DRB Application No.: 06DRB-00820 (P&F)  
Project Name: LANDS OF SALAZAR FAM TRU  
Agent: Community Sciences Corp.

Project # 1004184  
Phone No.: 897-0000

## OFFICIAL NOTICE OF DECISION

- 3. Project # 1004184**  
06DRB-00819 Major-Bulk Land Variance  
06DRB-00820 Minor-Prelim&Final Plat Approval

BULK LAND PLAT
TRACTS A-1-A, A-1-B AND A-1-C
LANDS OF SALAZAR FAMILY TRUST, ET AL
 RIO BRAVO SECTOR DEVELOPMENT PLAN
 SITUATE WITHIN
 PROJECTED SECTION 4, T.9N., R.2E., N.M.P.M.,
 TOWN OF ATRISCO GRANT
 CITY OF ALBUQUERQUE
 BERNALILLO COUNTY, NEW MEXICO
 APRIL 2006

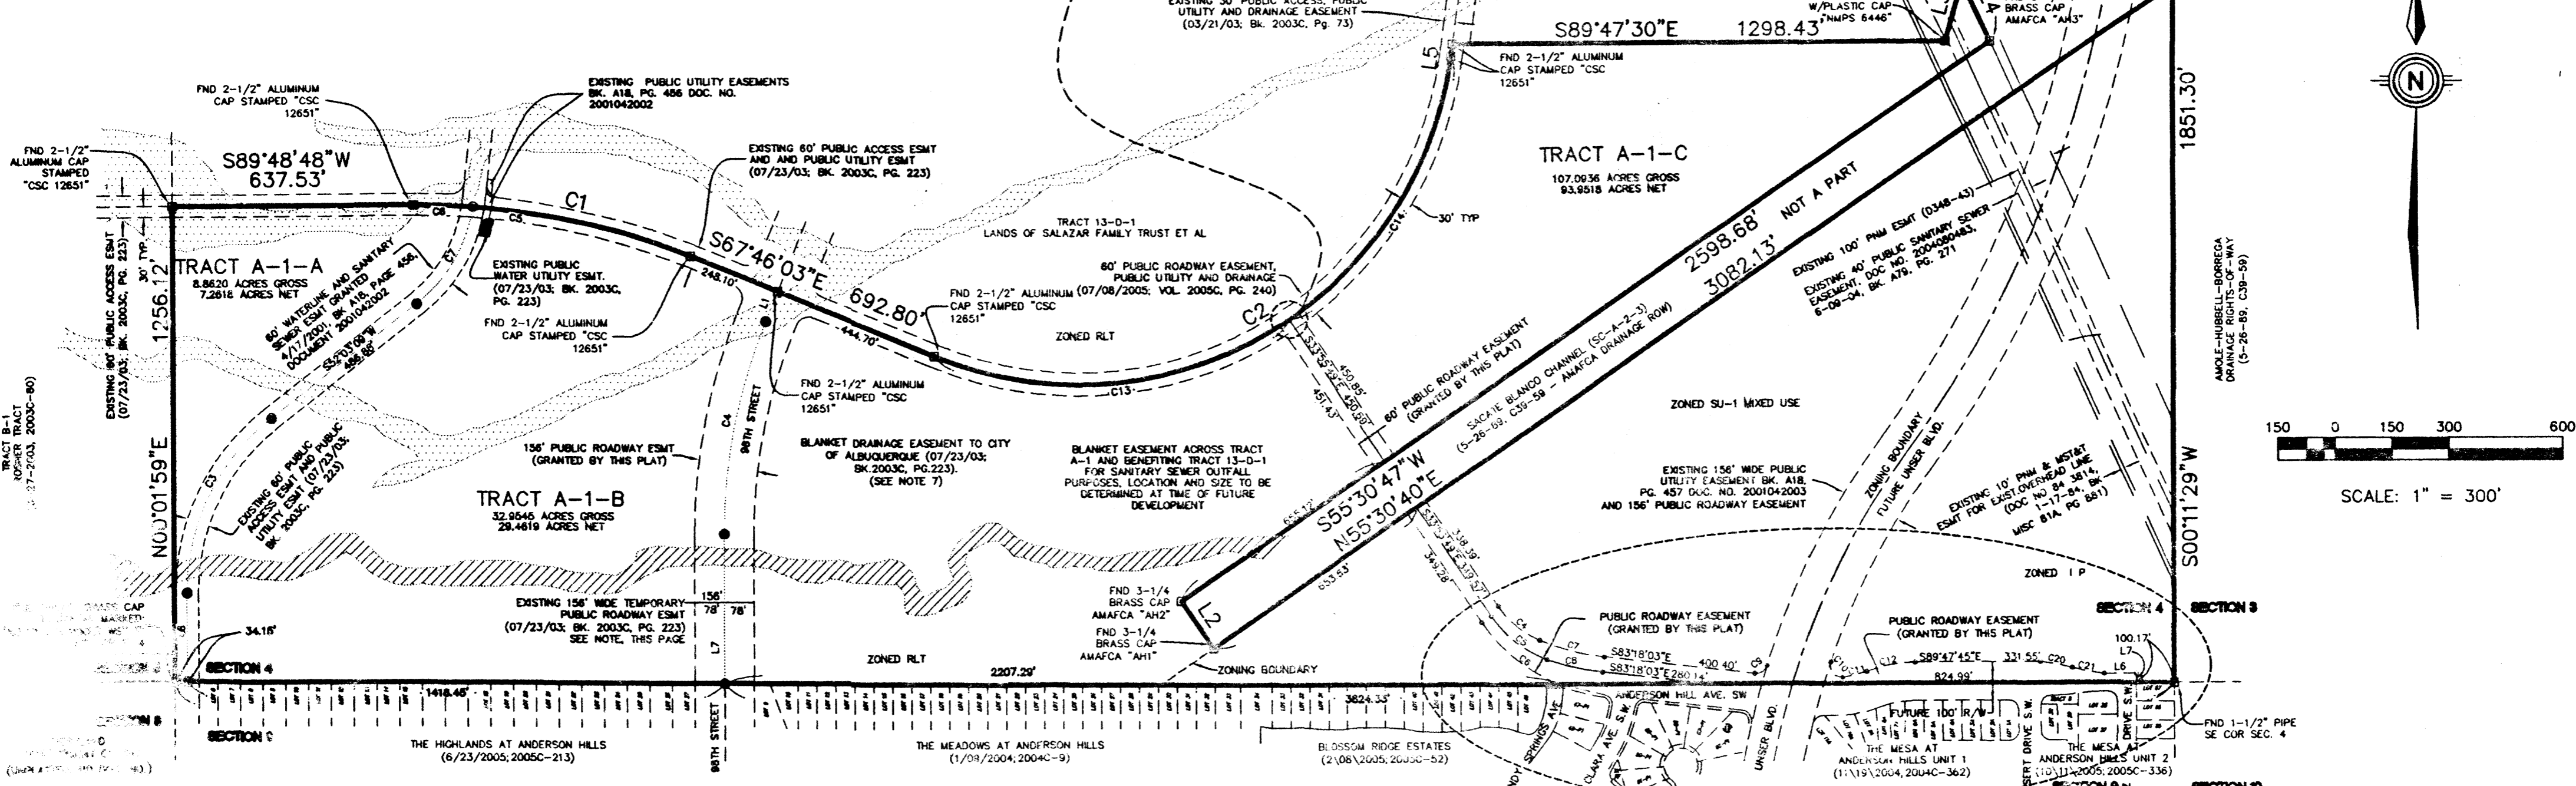
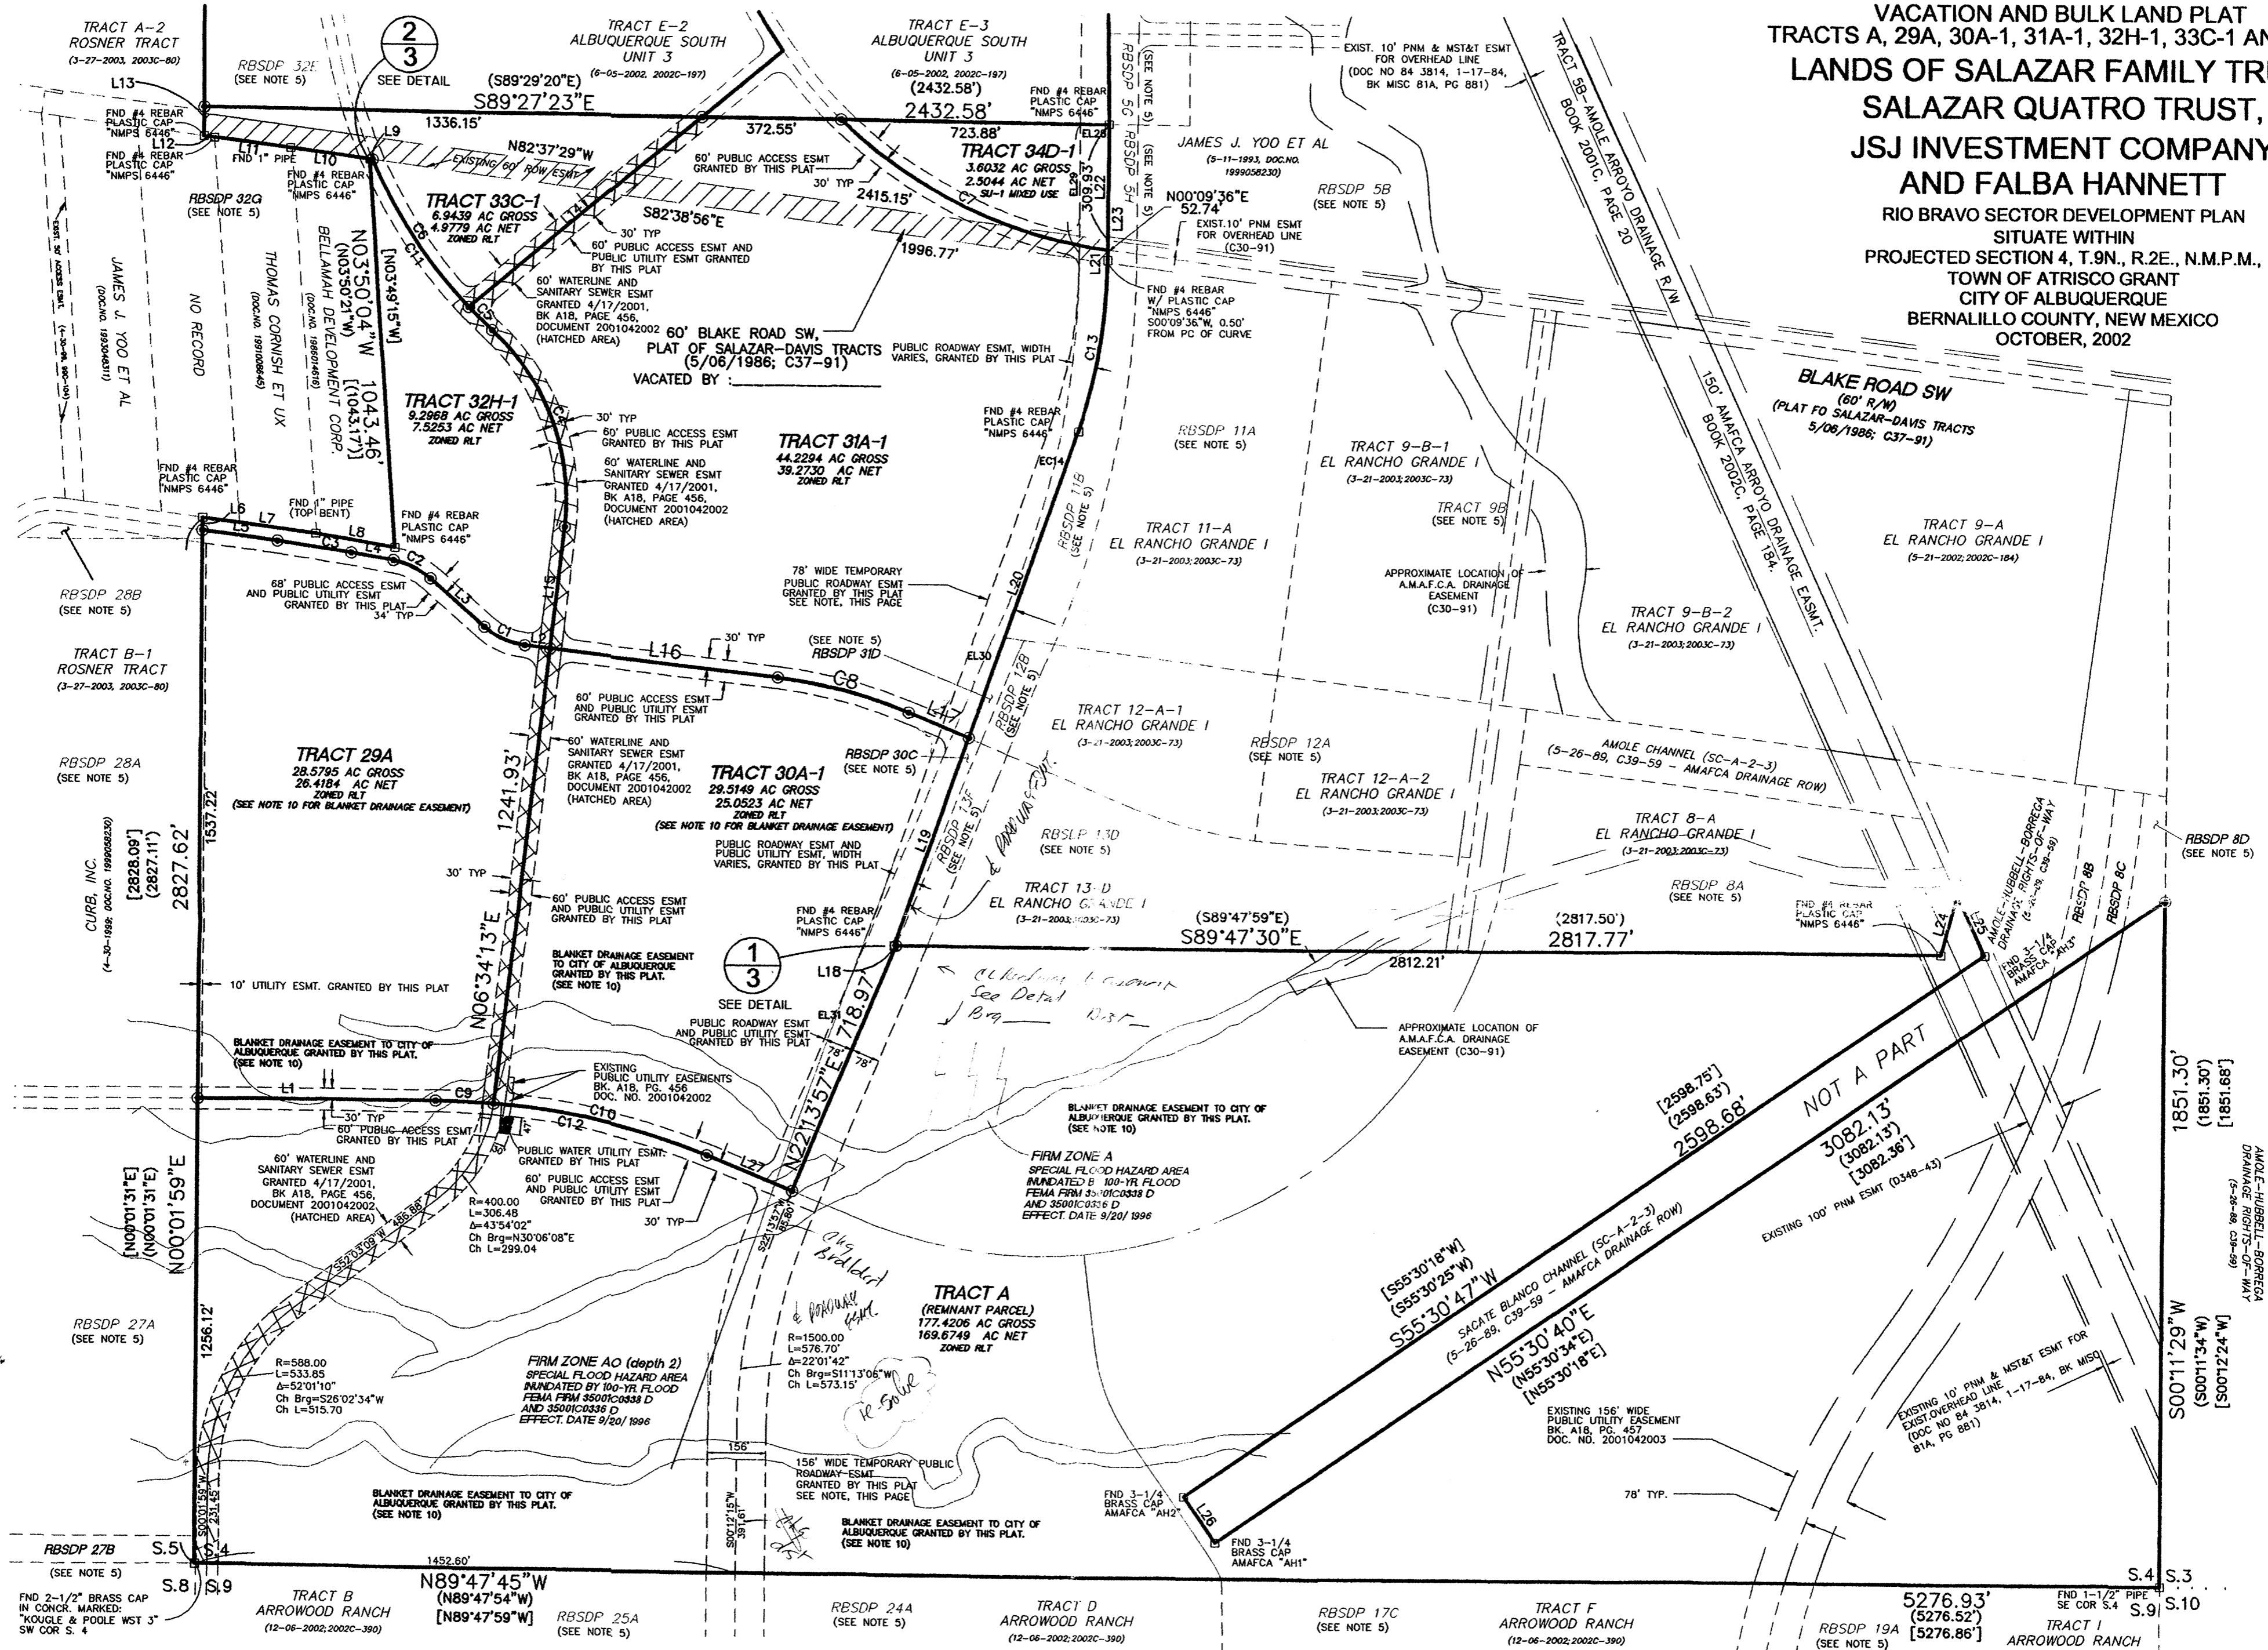
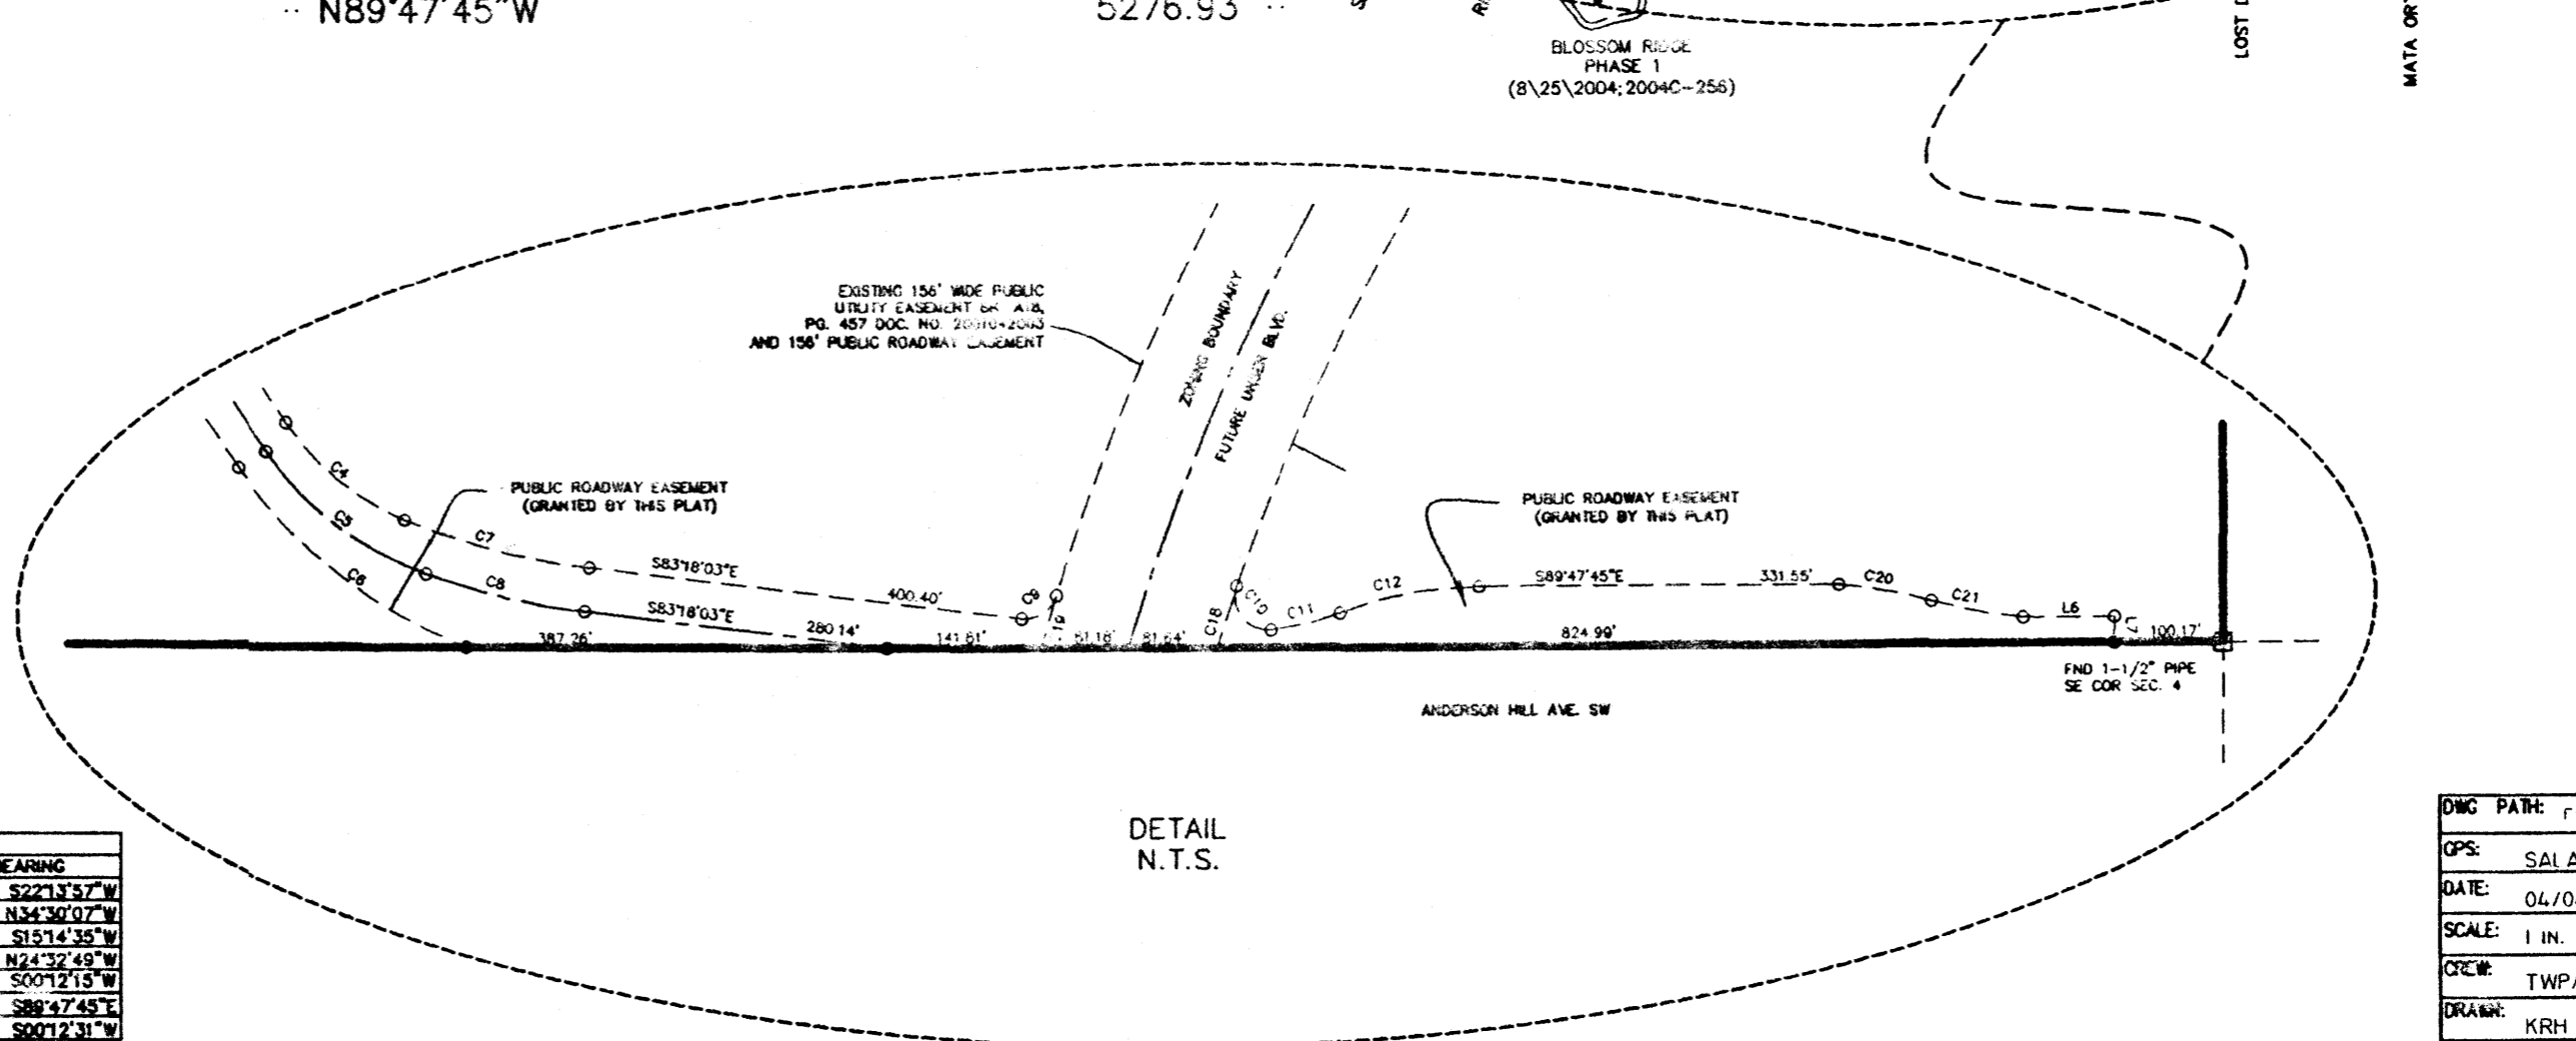
- TRANSPORTATION: Removal of PUBLIC UTILITY ENCUMBRANCES
- DEDICATION of PERMANENT 90<sup>th</sup> ST. ENCUMBRANCE.
- 
-

- PLANNING (Last to sign): ✓ Zoning on 1<sup>st</sup> page of Plat
- Record the Plat
- 15 day appeal period
- Missing → Bulk Land variance documents — On the Plat
- AMAFCA sig. — itself

No objection with the BLV. AMAFCA must sign plat. Location of new access easement needs discussion.

Transportation Development 98<sup>th</sup> Street needs to be granted as a permanent public roadway easement.

No objection to Bulk Land Variance. Why are Public Utility Easements being granted with the Public Roadway easements?

The current zoning should be added to the first page of the plat before Planning signs the plat.
